From: Simon Davis
Sent: 19 February 2019 16:28
To: Planning.Responses
Subject: FW: Planning Consultation on: BE/131/18/PL

From: Laura Gibbons
Sent: 19 February 2019 11:29
To: Simon Davis <Simon.Davis@arun.gov.uk>
Subject: RE: Planning Consultation on: BE/131/18/PL

Engineers comments regarding requested amendments to conditions 9, 10, 11 and 12

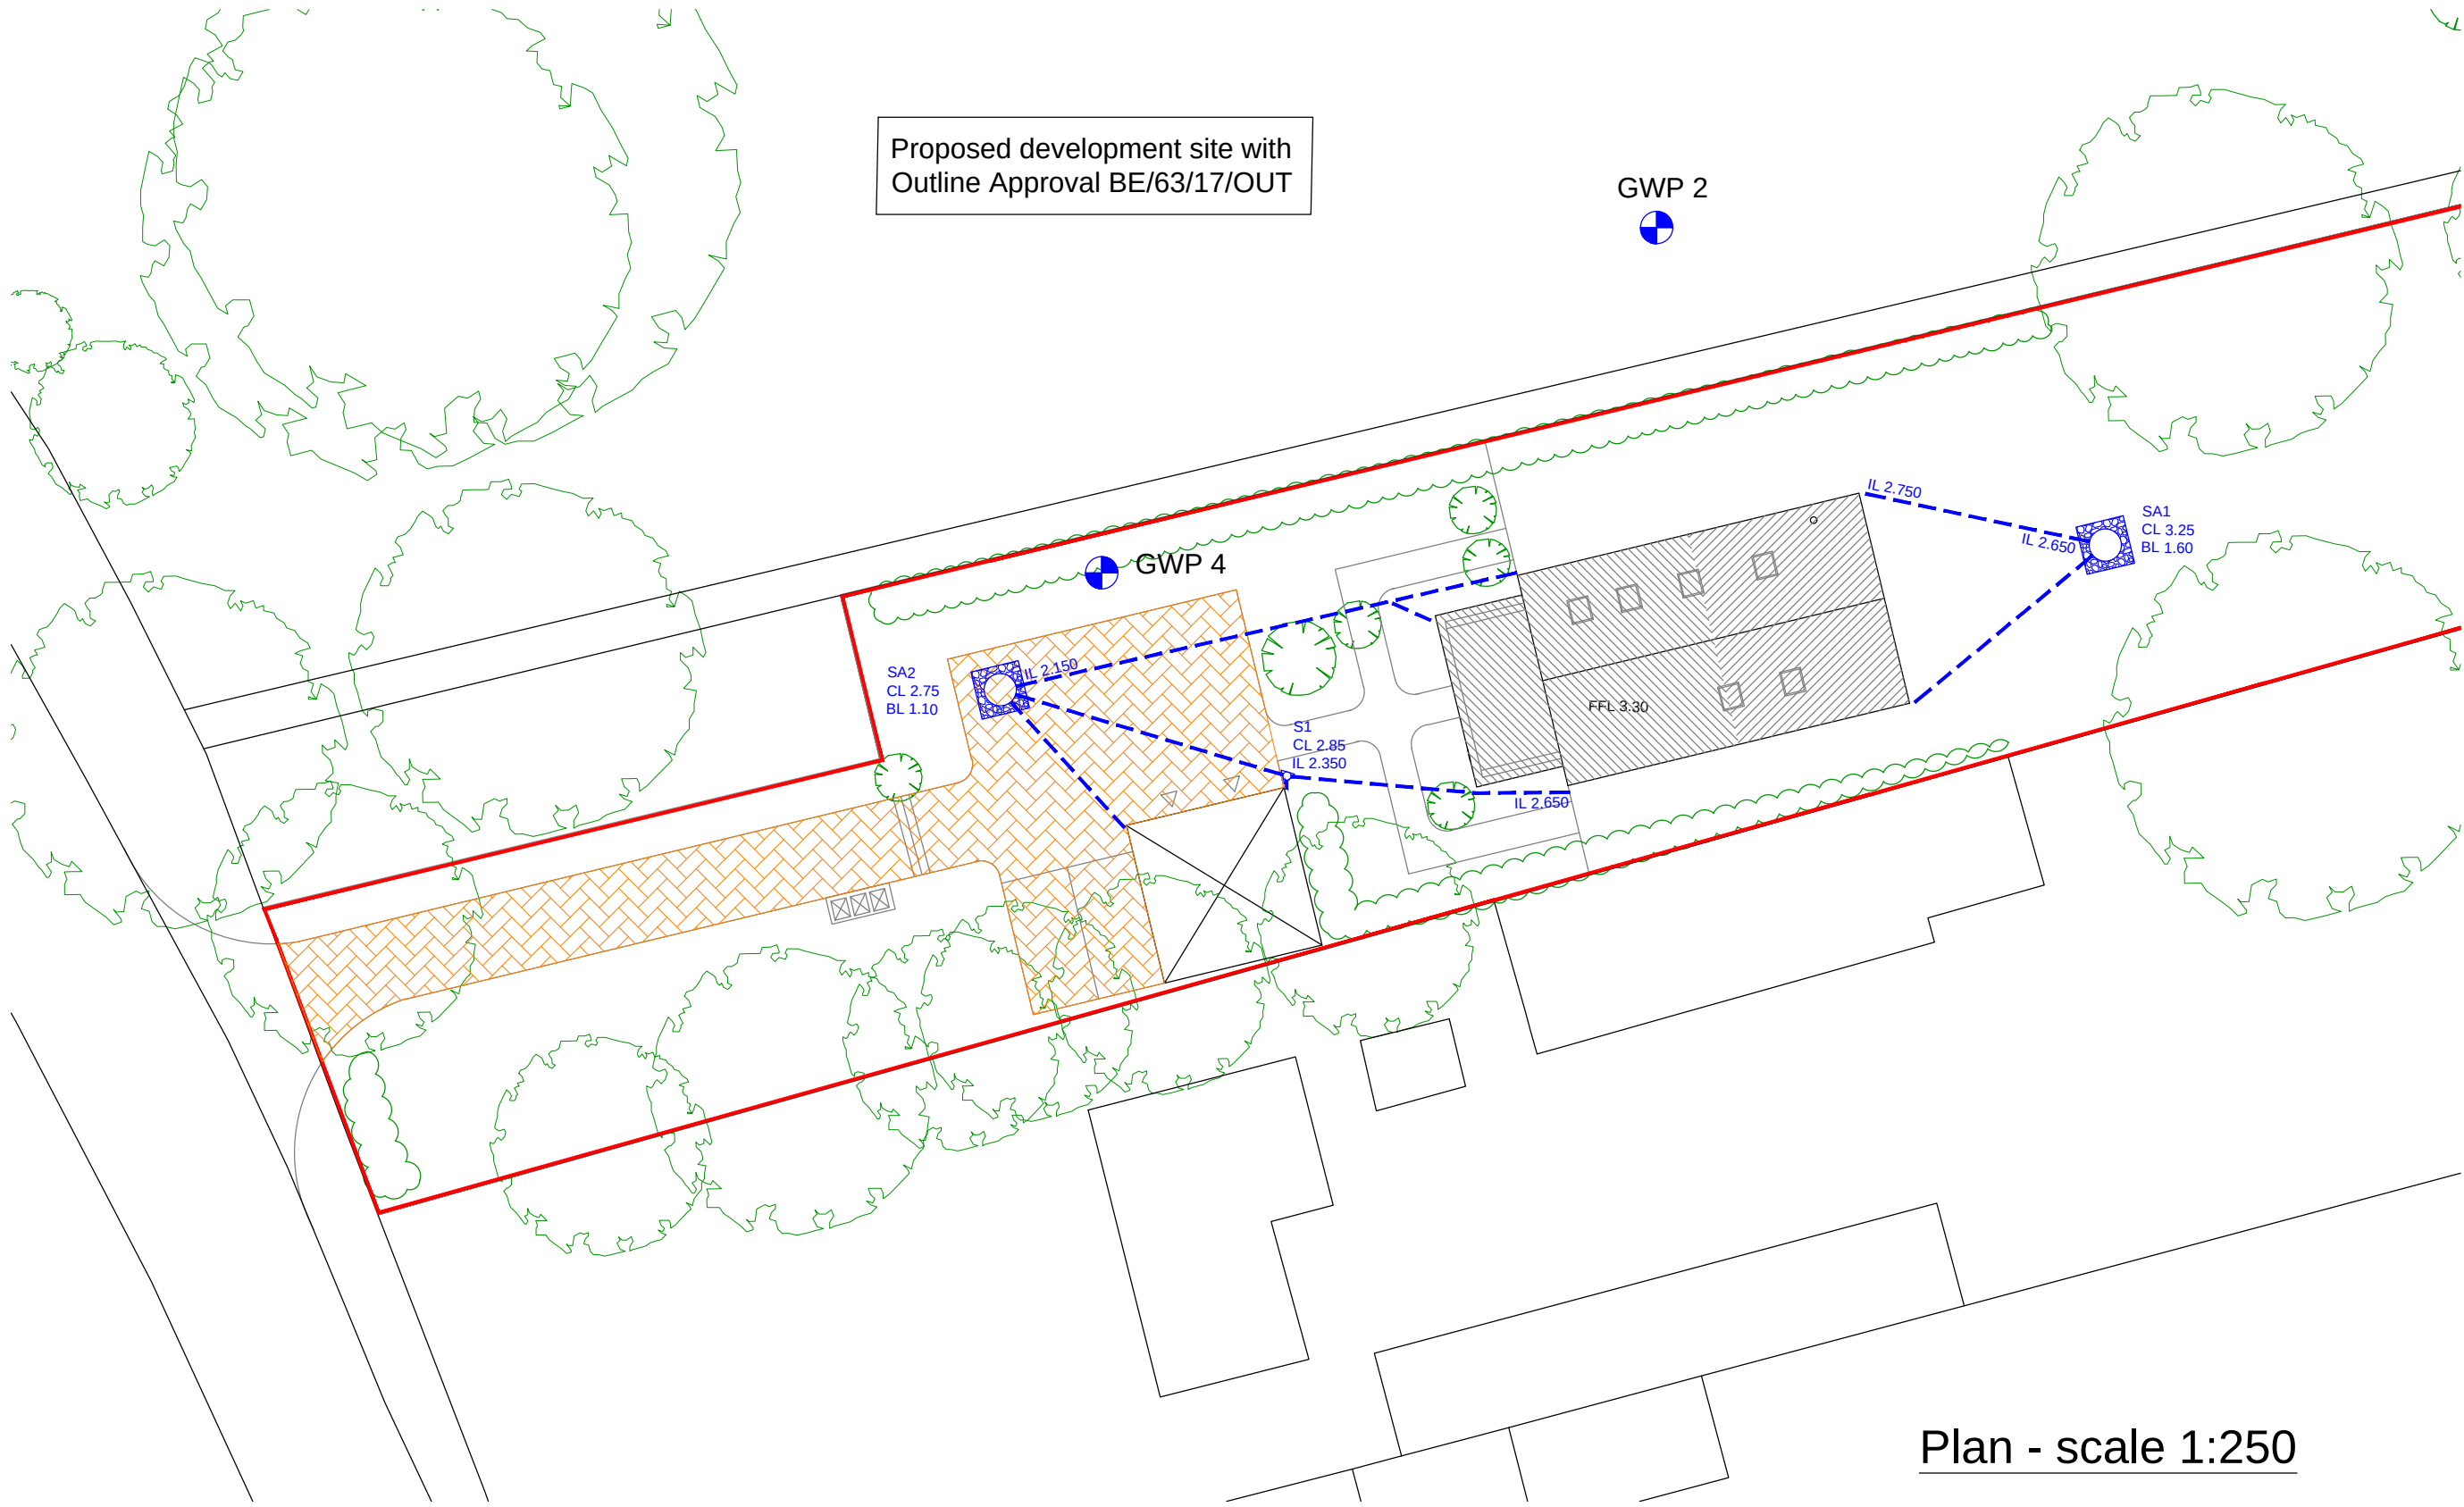
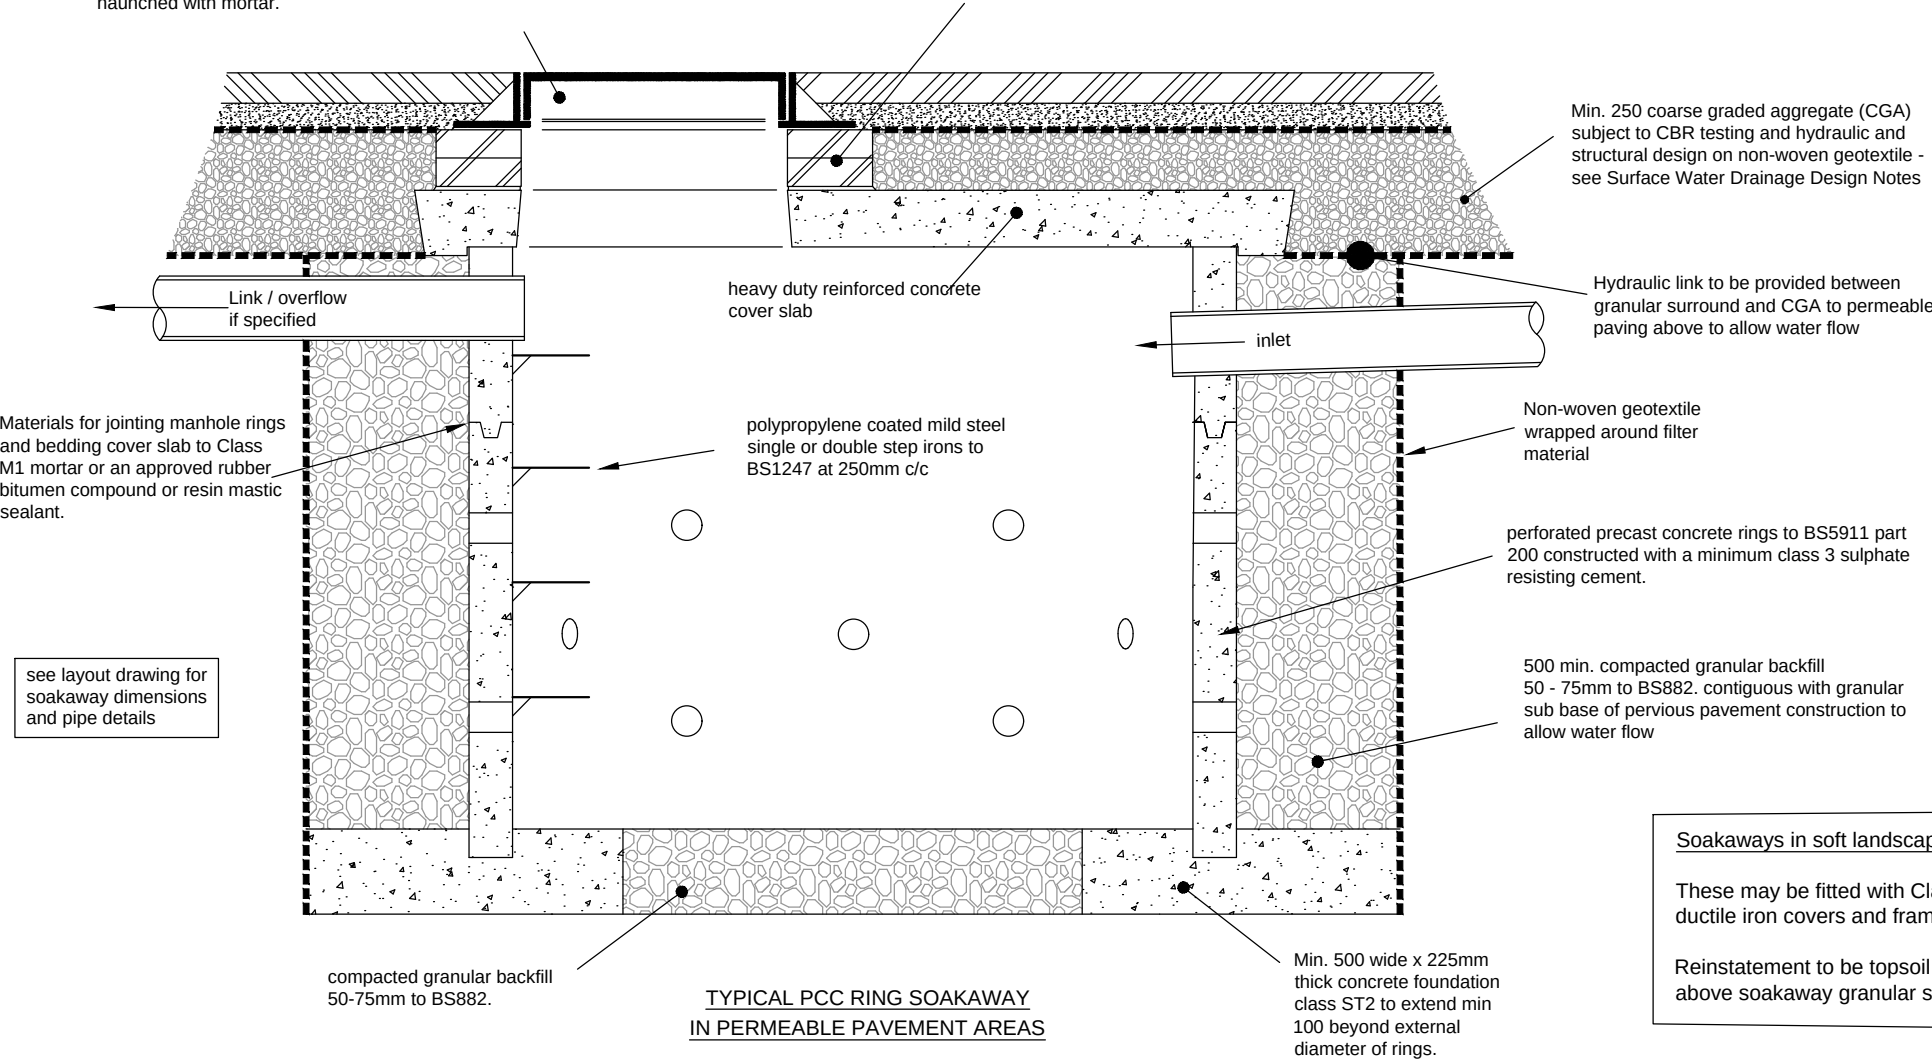
I was not initially aware but it transpires that groundwater monitoring had been undertaken at The Cottage, Shripney Road for a number of months. Please find attached the results of this monitoring and a plan showing the proposed drainage strategy for the proposed chalet bungalow to the south (phase 1). As you can see from the plan, the proposed method of surface water disposal is via a combination of permeable paving and soakaways.

It is unclear what winter groundwater levels are at the site. If it is found that groundwater levels are too high to permit infiltration, or that infiltration is too slow even phase 1 will have to drain to the ditch. Without winter groundwater monitoring phase 1 wouldn't comply with building regulations approved document H. It is possible that the drainage of phase 1 and 2 will need to be interconnected. Therefore I do not recommend the alteration to conditions 9, 10 or 11. However, I am satisfied that the wording of condition 12 can be amended.

I have reviewed the supplied information and sufficient monitoring has been completed for Phase 1. The details are also sufficient to enable the discharge of conditions 9, 10 and 12 for phase 1 should the applicant submit a DOC application.
